Subject: RE: Land off Arundel Road

Strategic Development Principal Planning Officer, Planning.

Reserved matters application

Marlow
Heritage Collection
F Series
1289ft² 119.79m²
Elevation Code: A1
Date: Jan 2020
EF_MARO_DM.3

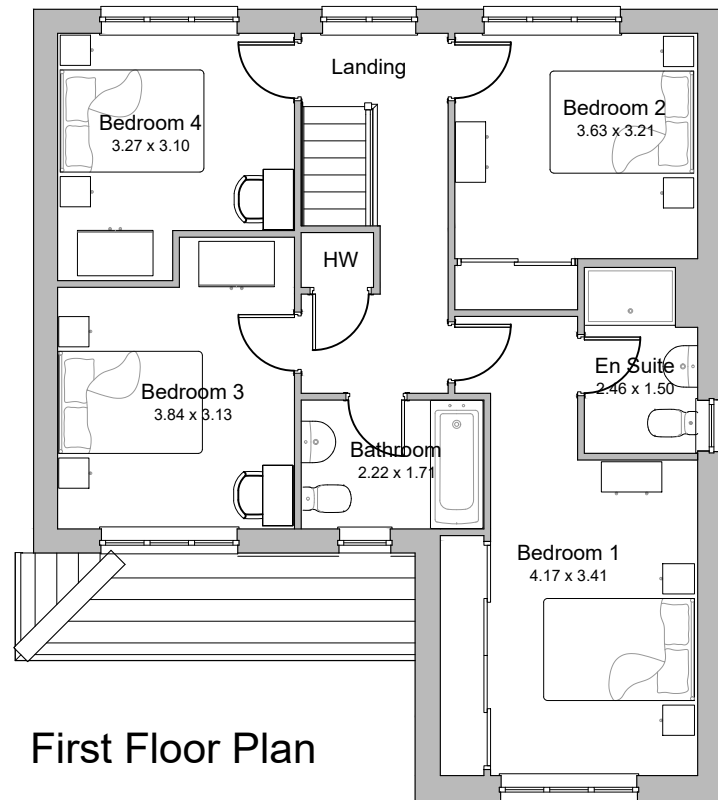
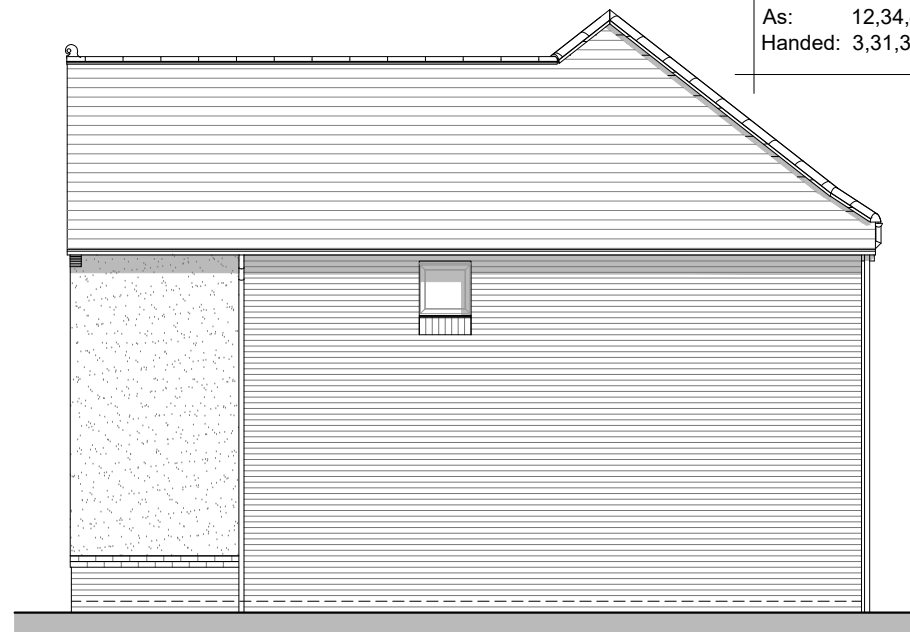
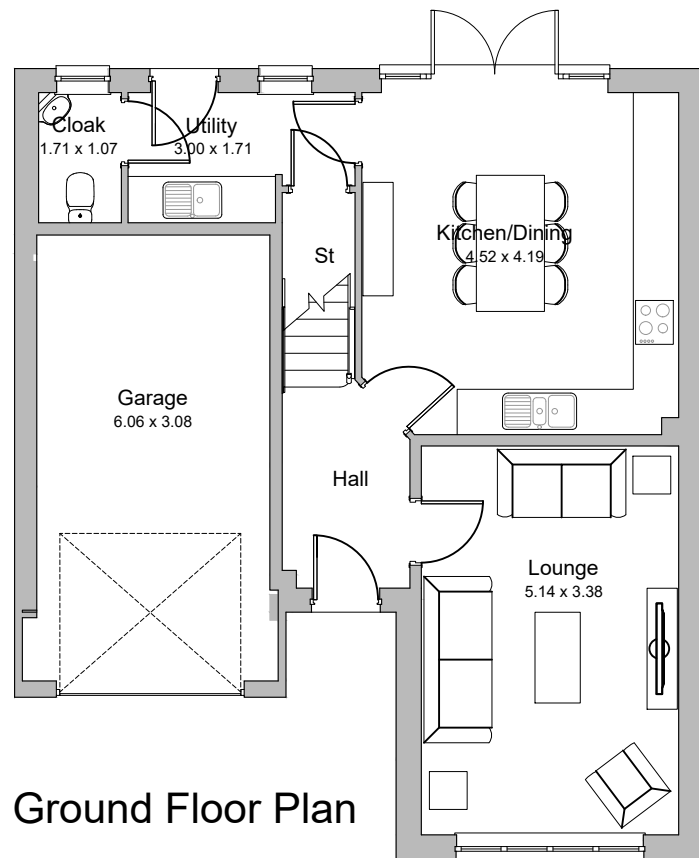
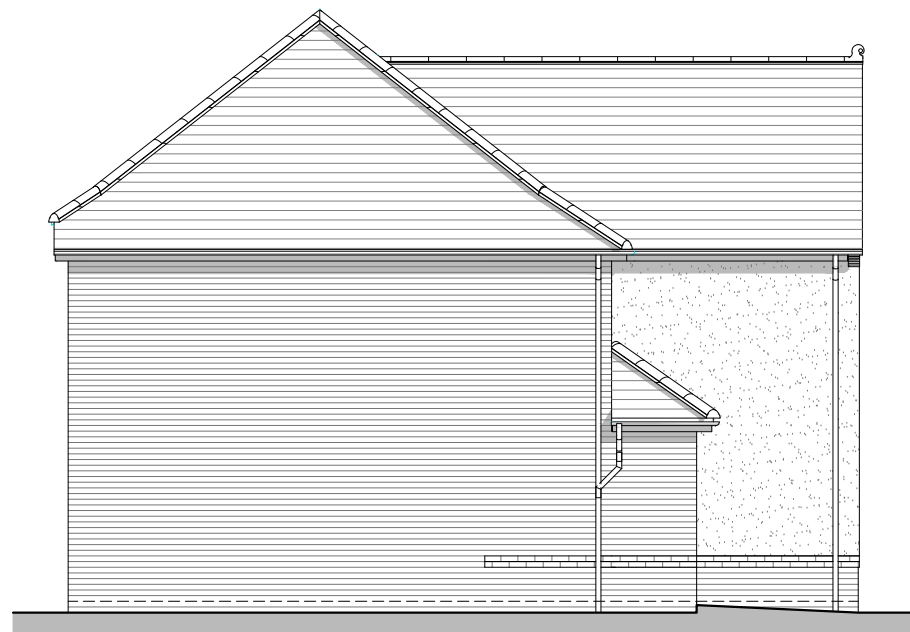
- Four dwellings now face the sports pitches, however more could be done to provide natural surveillance to this area.
- The use of white cladding is still evident, and has not been removed from the scheme. The parish council have also raised whether the dark mock Tudor style gables are characteristic of the area. There is no evidence to show that this choice of material and design is appropriate for this locality. We would seek the development to reflect the context of Angmering, rather than off the shelf-designs.

We previously raised concern with some of the material choices, these have not been revised. The use of white cladding, and mock Tudor external finishes are not characteristic of the area, and are therefore unacceptable for this locality.
